Consultation Response from KC, Conservation & Design**2023/91452 Thorn Bush Farm, Miry Lane, Hightown, Liversidge, WF15 8JJ****Listed Building Consent for partial demolition and rebuilding of farm house and erection of extensions and alterations to farm house, outbuildings and barn/stable to form visitor attraction with cafe, shop, class rooms, children's play area and associated car parking****Date Responded: 30.6.2023****Responding Officer: Sue Brooks****Responding Ref:**

Client:  
 Jan Capital Ltd  
 Drawing:  
 Site/Roof Plan As Proposed

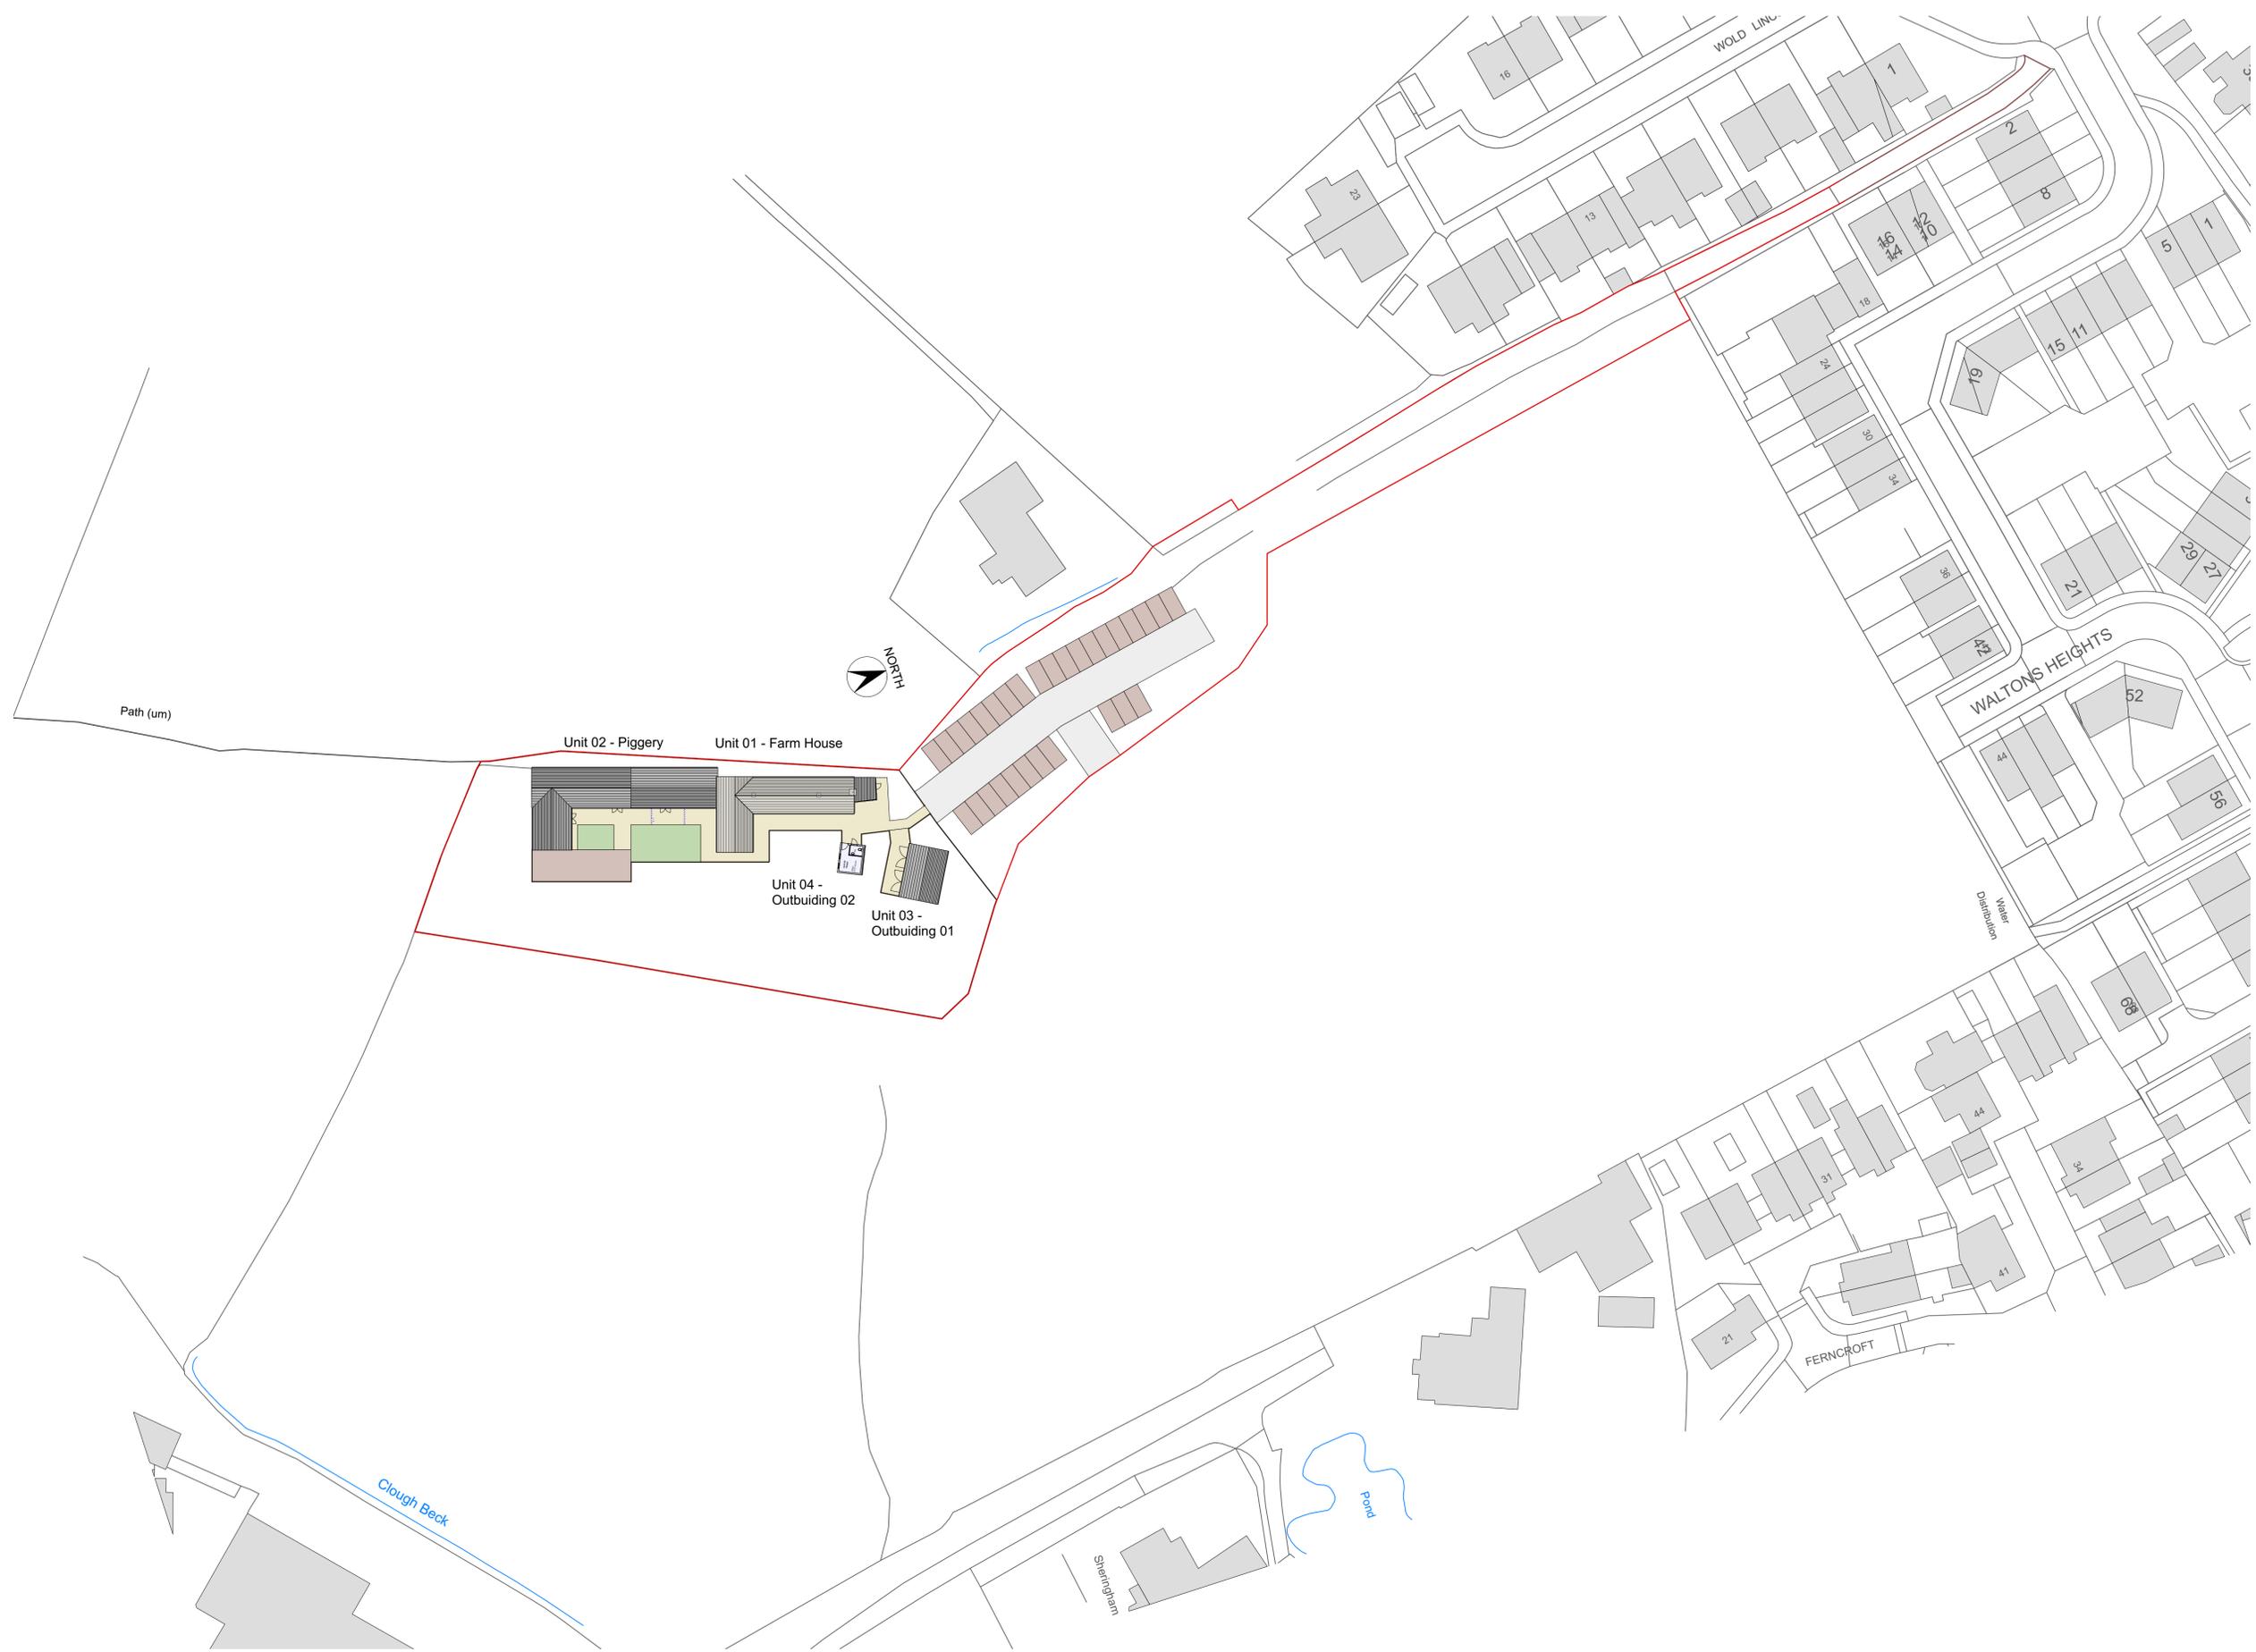
Any landscaping, car parking and ancillary equipment associated with the proposed visitor centre and museum will harm the setting of the historic cottages by the introduction of an access road and car park, external play area, lighting and security works within the curtilage and in the wider landscape.

A brief schedule of works has been submitted but the details within this are limited. A carefully considered and sensitive scheme needs to be included within a heritage impact assessment which should assess the level of harm, mitigate it as far as possible and provide public benefits to outweigh it where it is unavoidable.

Drawing:
 Unit 01 and 02 Plans
 As Proposed

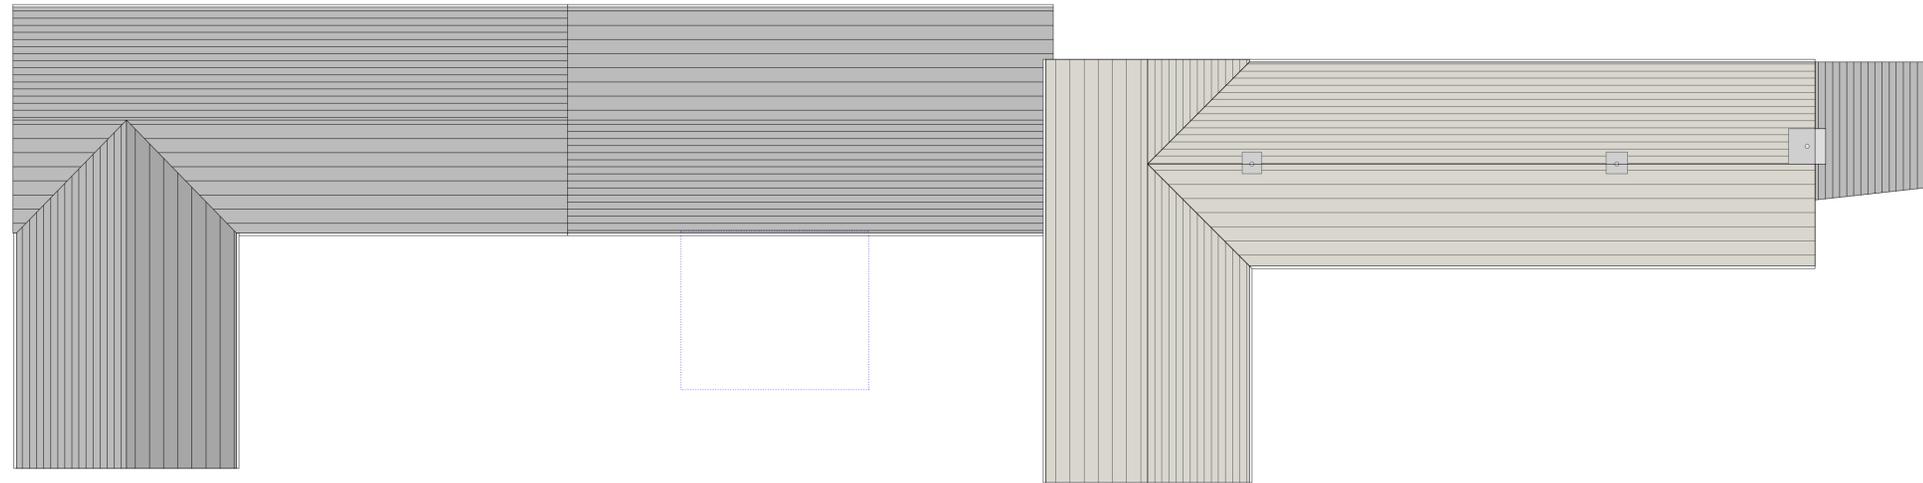
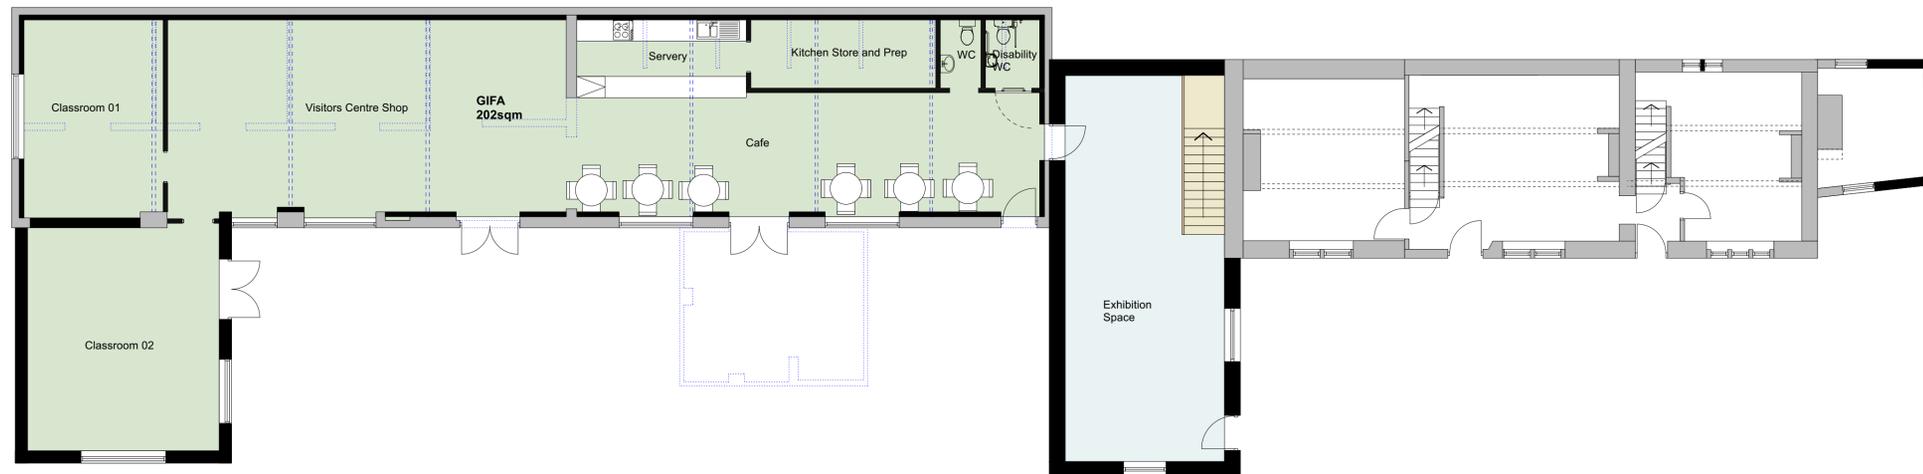
The applicant proposes artificial stone slates for the roof covering of the cottages as the existing covering has been removed. The heritage statement states that artificial slates are more lightweight than natural stone slates and could be laid on the existing structure without the need for extensive strengthening. Given the extremely poor condition of the roof structure, we would expect it to require strengthening and would recommend that structural recommendations are submitted for carefully designed strengthening works which would allow natural slates to be laid. We do not consider the current justification and level of information to be adequate.

The applicant proposes to convert this building, with the central projection demolished and a new extension built onto the southern end. As this structure already harms the setting of the listed building, we are unable to support further development of this building.

Drawing:
 Unit 01 and 02 Elevations
 As Proposed

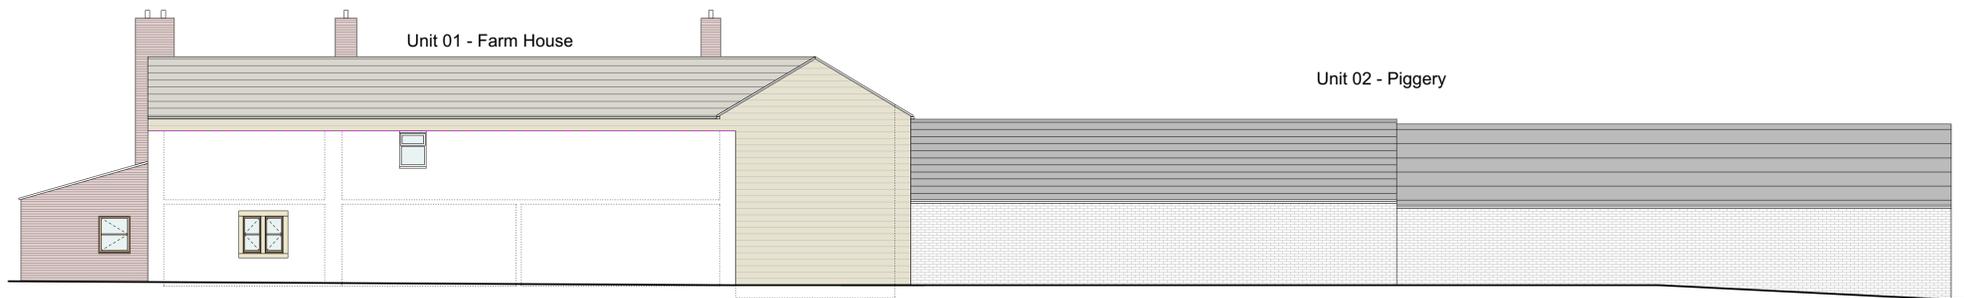
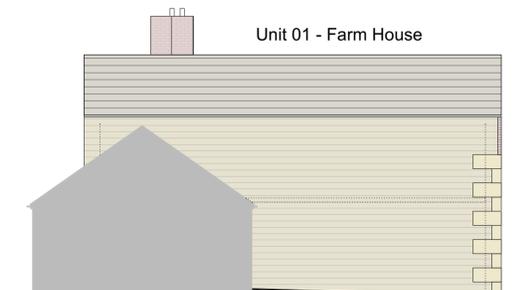
The proposed drawing specifies brickwork for the elevations and cast artstone for the quoins, heads, jambs and cills. The stone detailing should be in natural tooled stone and this can be agreed by condition.

The replacement of the existing corrugated asbestos roof with a natural blue/grey slate roof covering is acceptable as proposed in the application form (not imitation blue slates as proposed in the brief specification). The proposal for off white render on the south elevations, along with the character and material of the openings on this elevation, needs to be reconsidered and this can be dealt with by condition.
